**WELWYN HATFIELD BOROUGH COUNCIL  
EXECUTIVE DIRECTOR - PLANNING, PUBLIC PROTECTION AND GOVERNANCE**

**Application No:** 6/2019/0737/LAWP  
**Location:** Just House Coopers Lane Northaw Potters Bar EN6 4NJ  
**Proposal:** Certificate of lawfulness for an outbuilding  
**Officer:** Ms Lucy Hale

**Recommendation:** Refused

PROPOSED FRONT ELEVATION

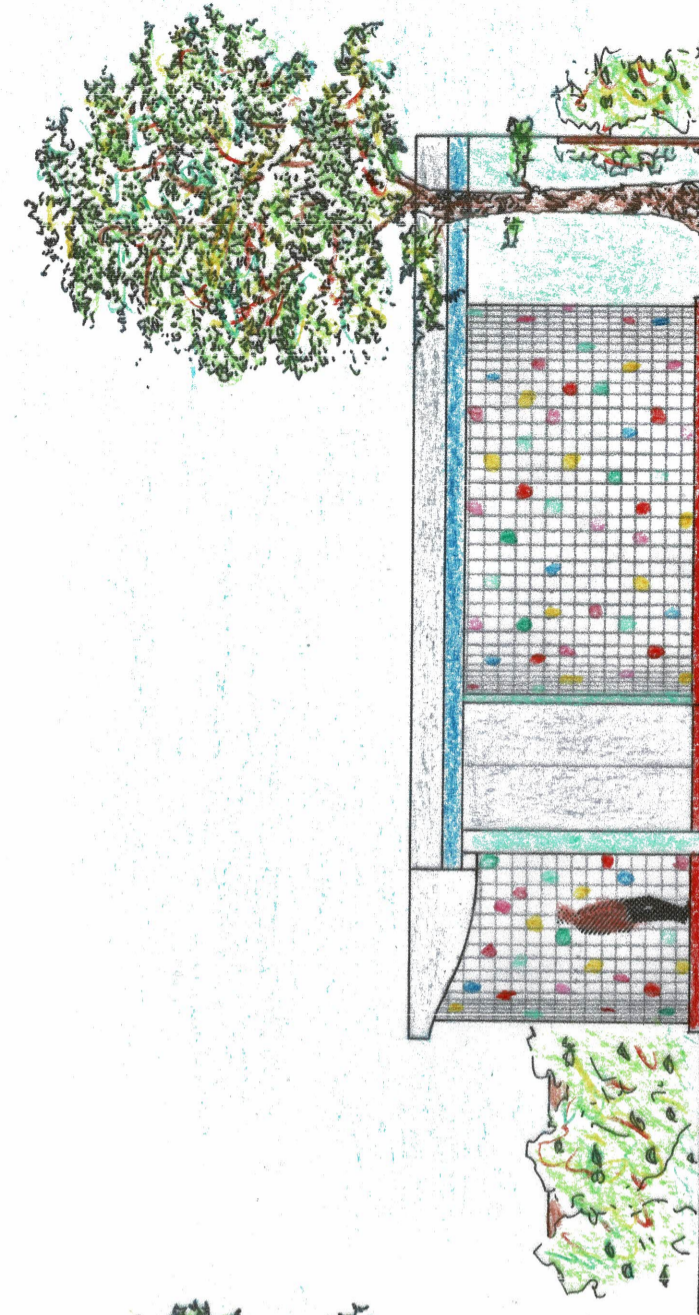
| The proposed outbuilding would measure 4 metres in height and would be located within 2 metres of the boundary of the curtilage of the dwellinghouse. The outbuilding fails to meet the requirement of e (ii) which restricts the building measuring higher than 2.5 metres within 2 metres of the boundary.                                       |   |    |

1. The proposed outbuilding would exceed the limitations of E.1(e) in Schedule 2, Part 1, Class E of the Town and Country Planning General Permitted Development (England) Order 2015 (as amended) by virtue of being situated within 2 metres of the boundary of the curtilage of the dwellinghouse and measuring more than 2.5 metres in height.
